KITTITAS COUNTY

MEMORANDUM

TO: All Staff
FROM: Public Works Plan Review Team
DATE: September 20, 2022
SUBJECT: BL-22-00020 Schulz

SCHULTZ PROPERTY

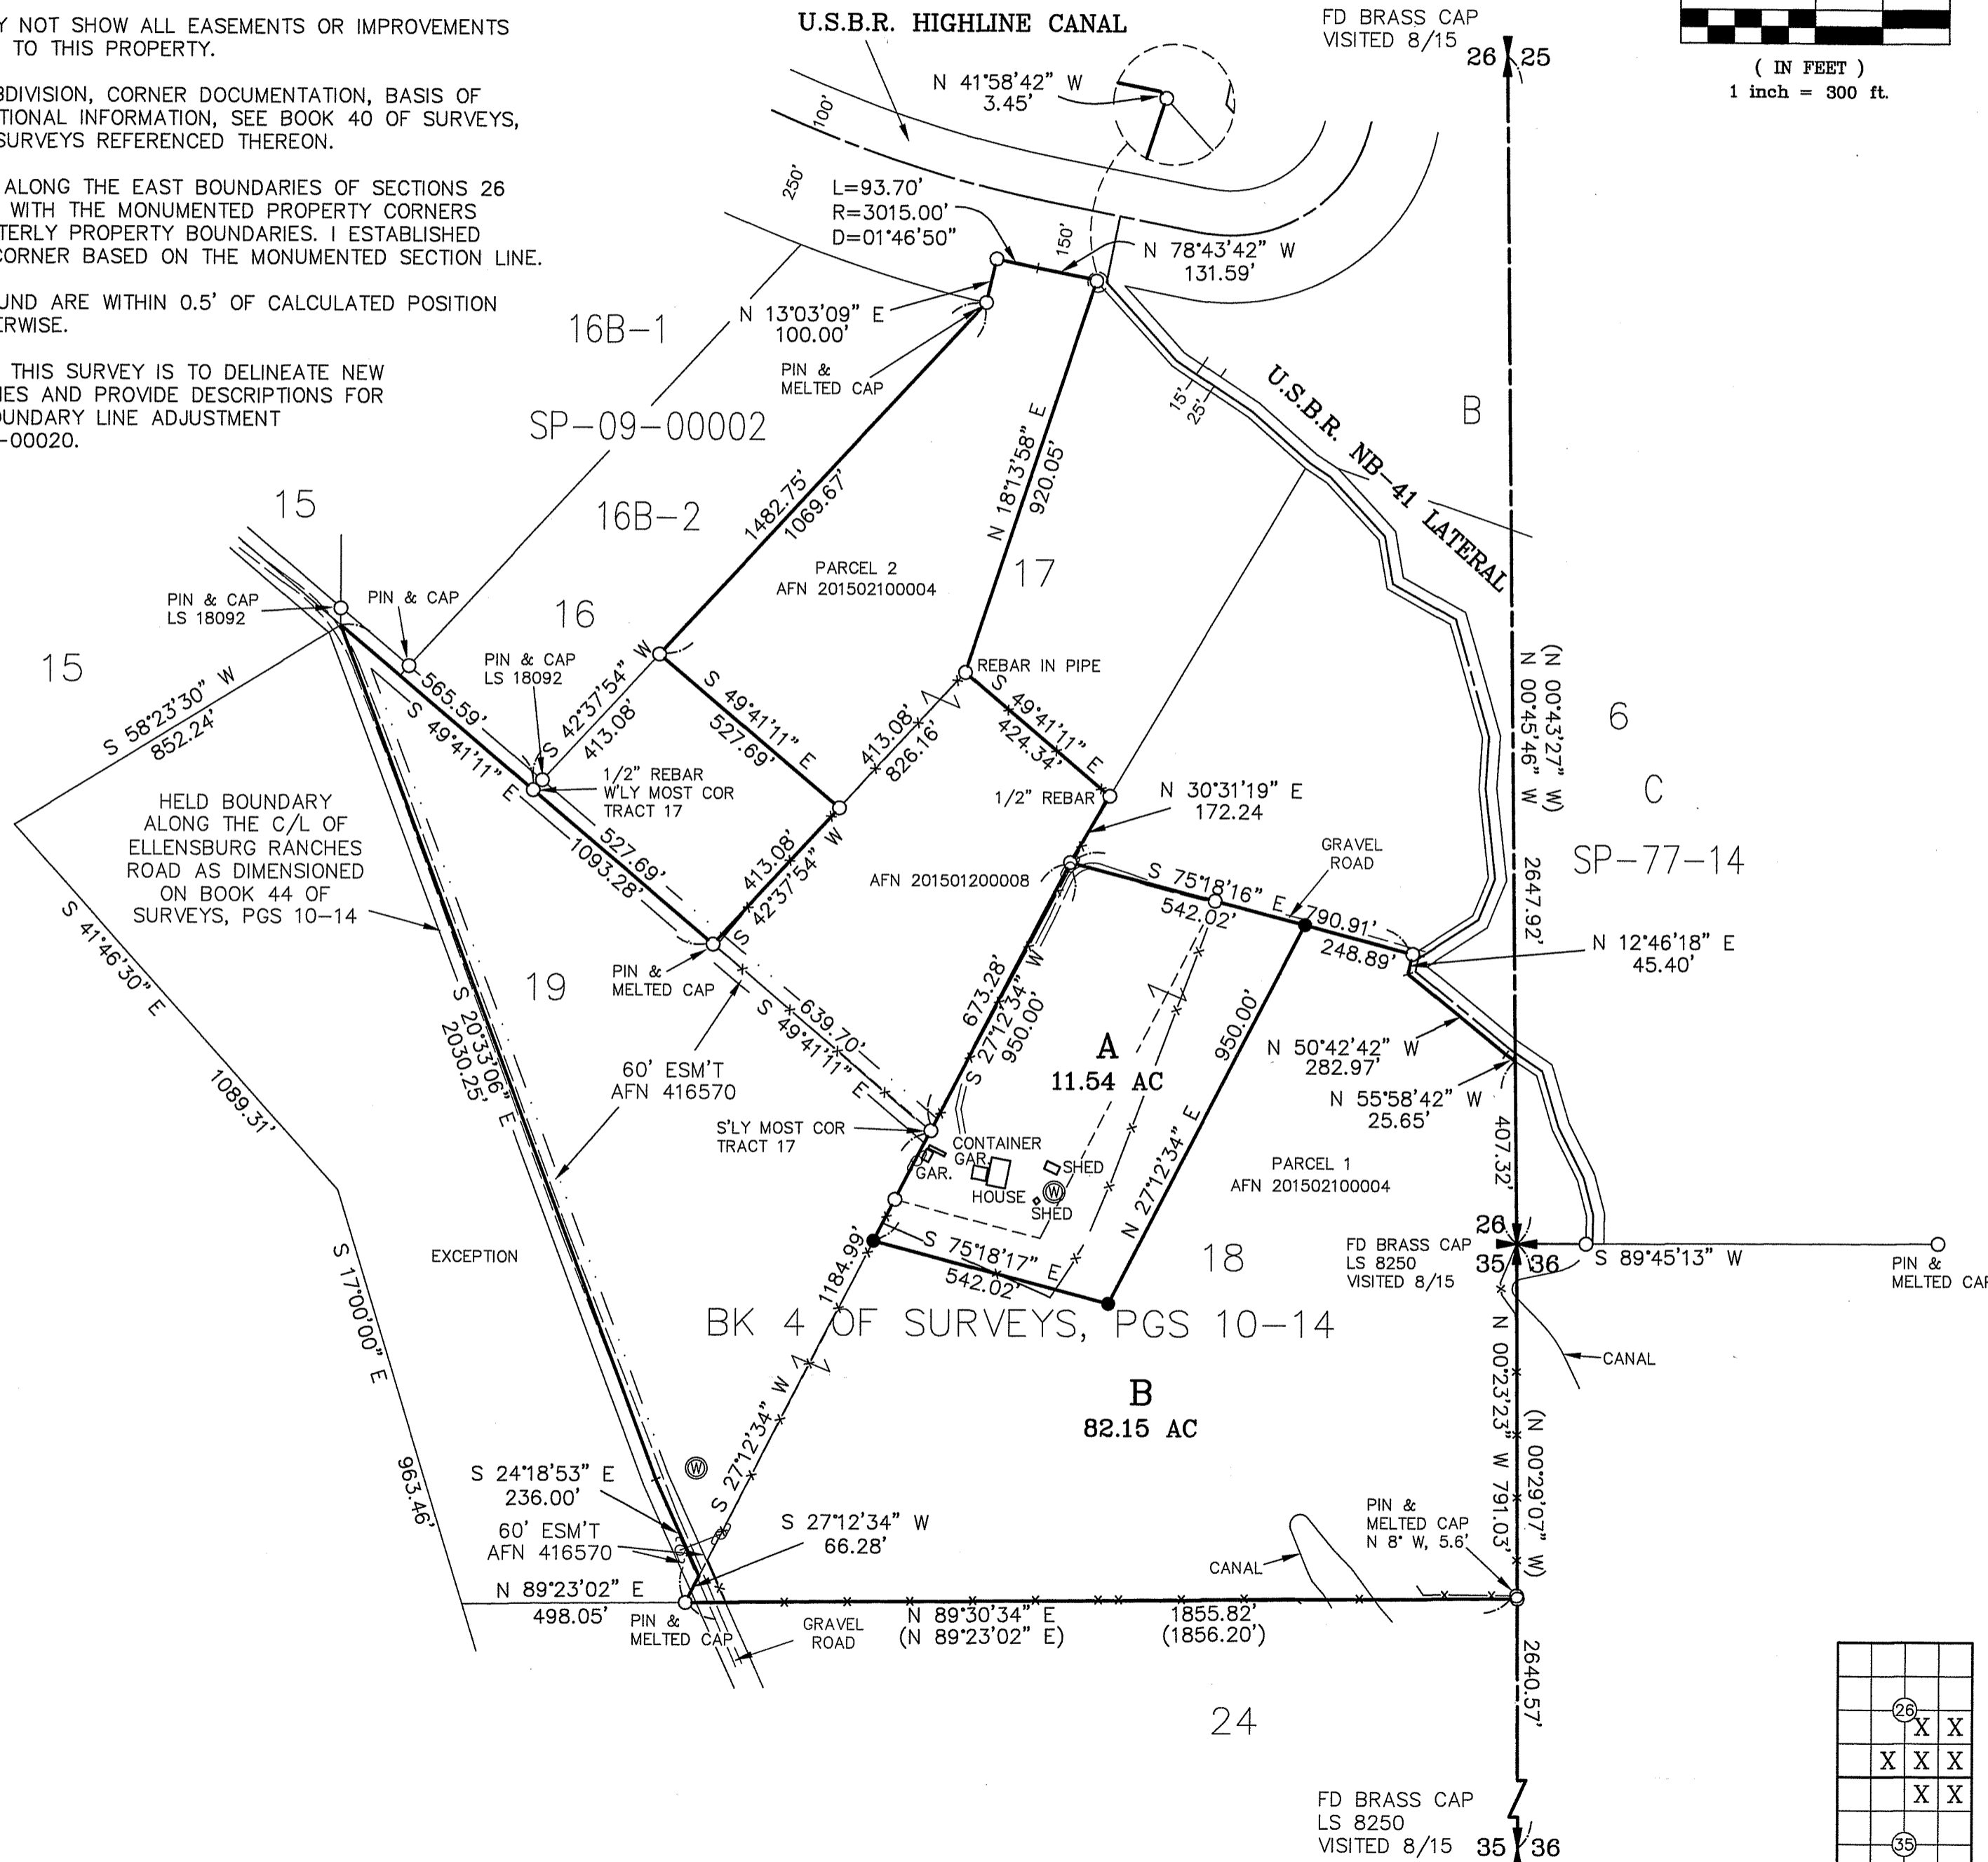
ACCESS	<ol style="list-style-type: none">1. An approved access permit shall be required from the Kittitas County Department of Public Works prior to creating any new driveway access or altering an existing access.2. Maintenance of driveway approaches shall be the responsibility of the owner whose property they serve. The County will not maintain accesses.3. Any further subdivision or lots to be served by proposed access may result in further access requirements. See Kittitas County Road Standards.4. In addition to the above-mentioned conditions, all applicable Kittitas County Road Standards apply to this proposal. Access is not guaranteed to any existing or created parcel on this application.
ENGINEERING	No Comments (CC).
SURVEY	Survey comments reserved until final submittal.(JT)
FLOOD & WATER MITIGATION/ METERING	No comments (SC)
